From: Ivon Blumer [REDACTED]
Sent: 31 March 2020 17:11
To: Amber Willard <Amber.Willard@arun.gov.uk>
Subject: Re: FP/13/20/PL

FP/13/20/PL at Beachcroft.

I have today received comments from our coastal engineer regarding the works to the sea wall.

PROJECT The Beachcroft Hotel - Terrace
TITLE Proposed Site Plan
SCALE As Noted
DATE 11/01/20
DRG NO IBA/526/02
REVISIONS A

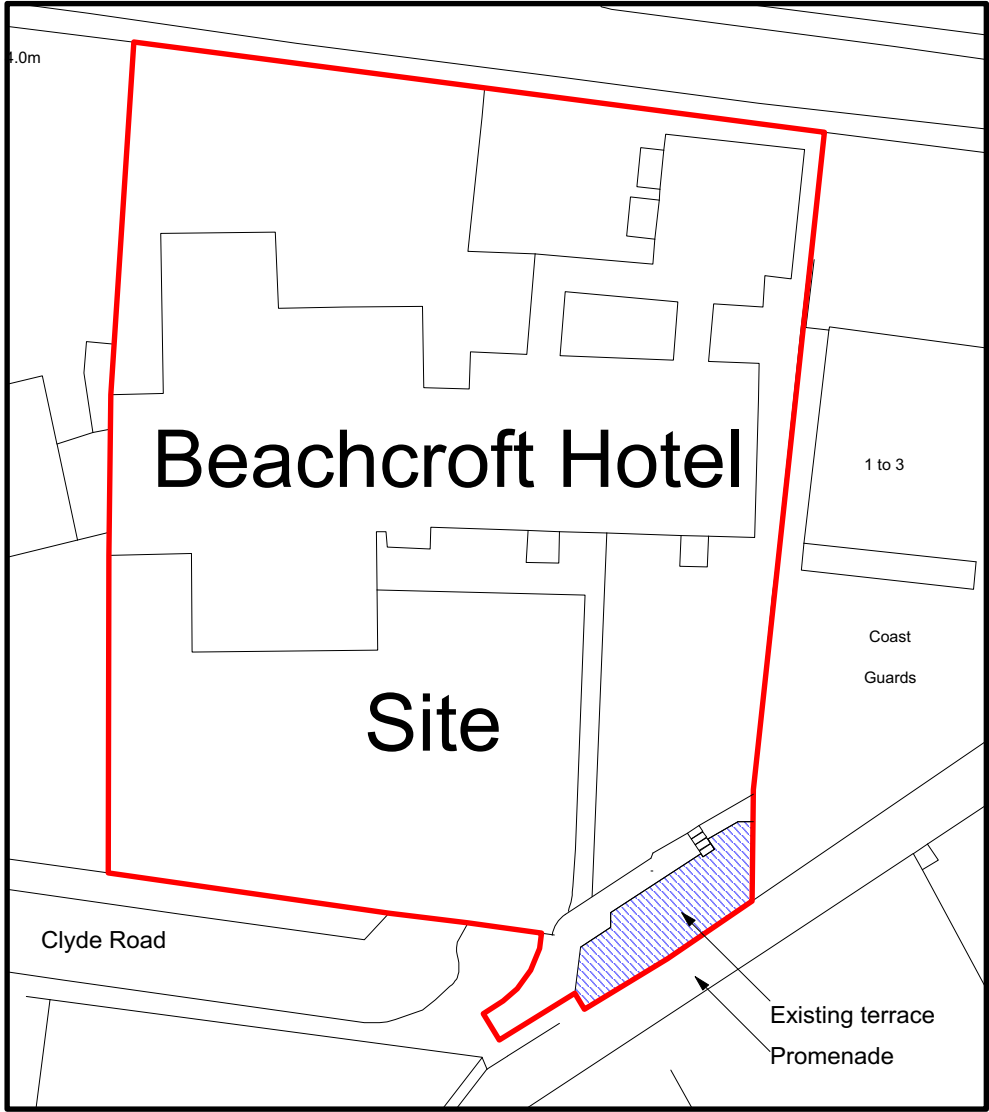
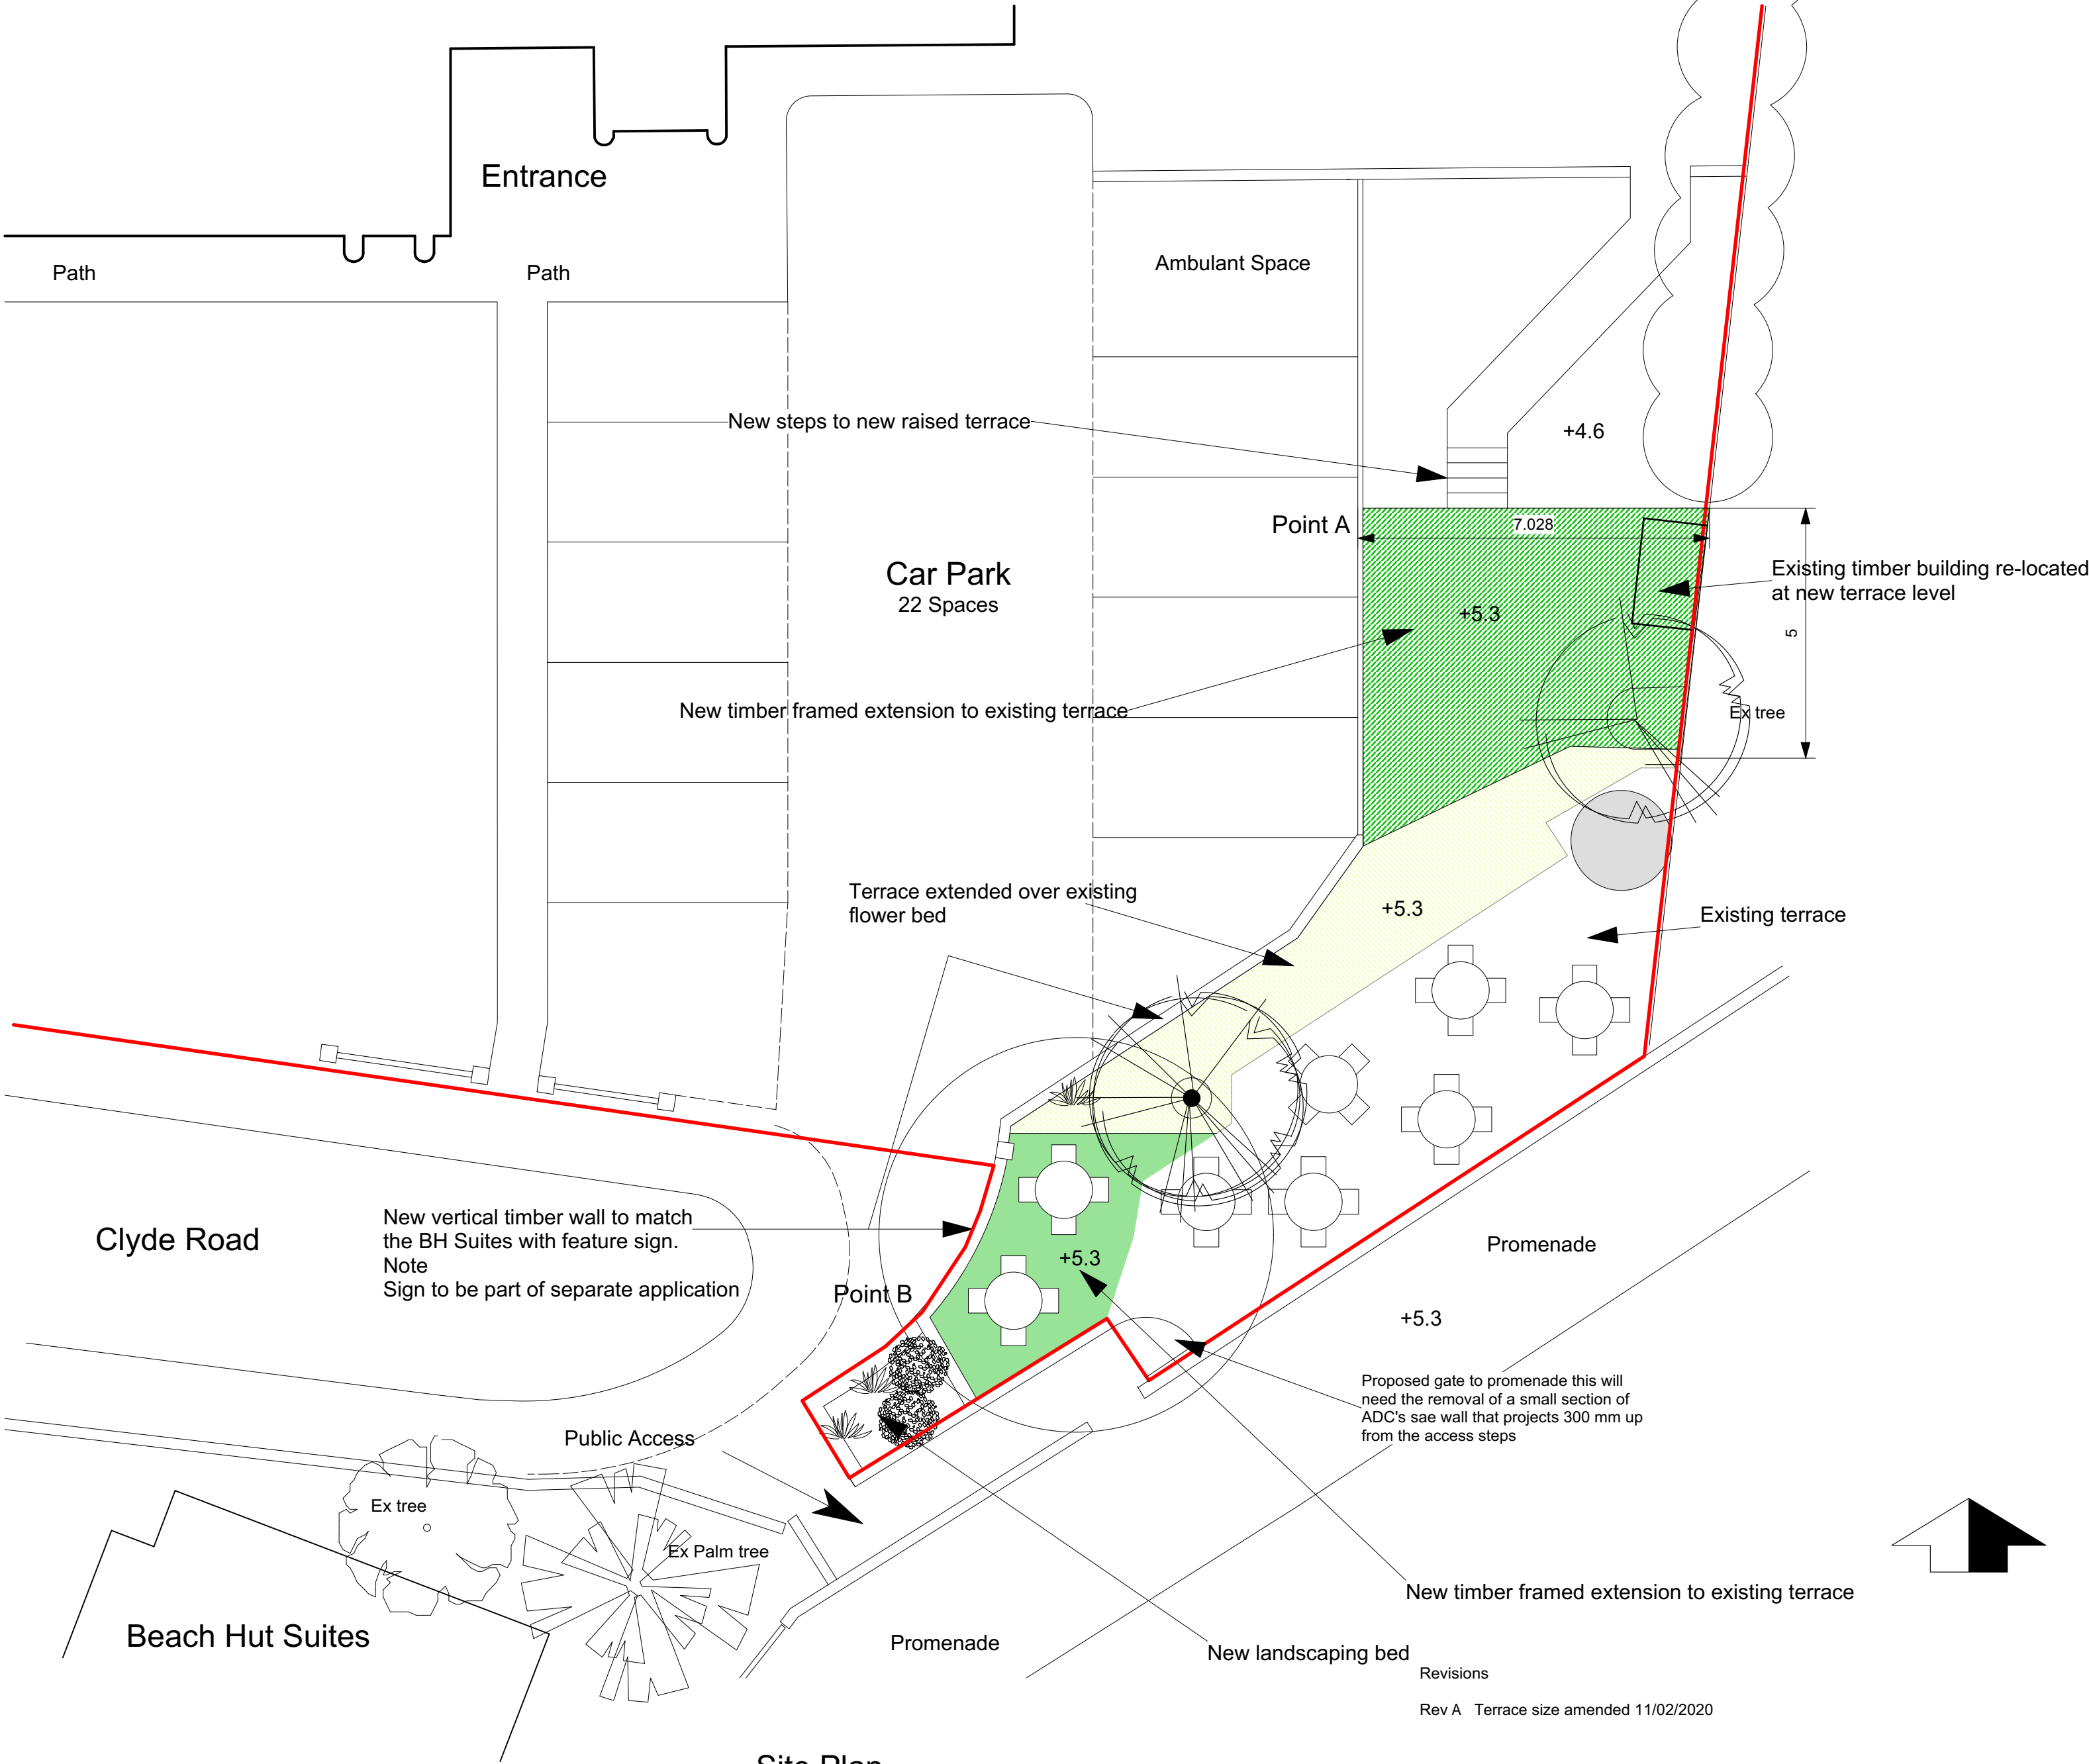
They have objected to the works as alterations to the seawall would compromise the integrity of the defence. This will be uploaded to view online. Under the Coast Protection Act the applicant would still need to serve notice on Arun District Council as the Coast Protection Authority, which would likely be objected to also.

Following their comments I would advise this is removed from the application. Please let me know if this something you would be willing to do. If so, please are able to amend the plan showing the no alteration to the wall and I can proceed to pass it through for determination.

No worries, I will do it tomorrow. Extension of time granted till 17/04/20.
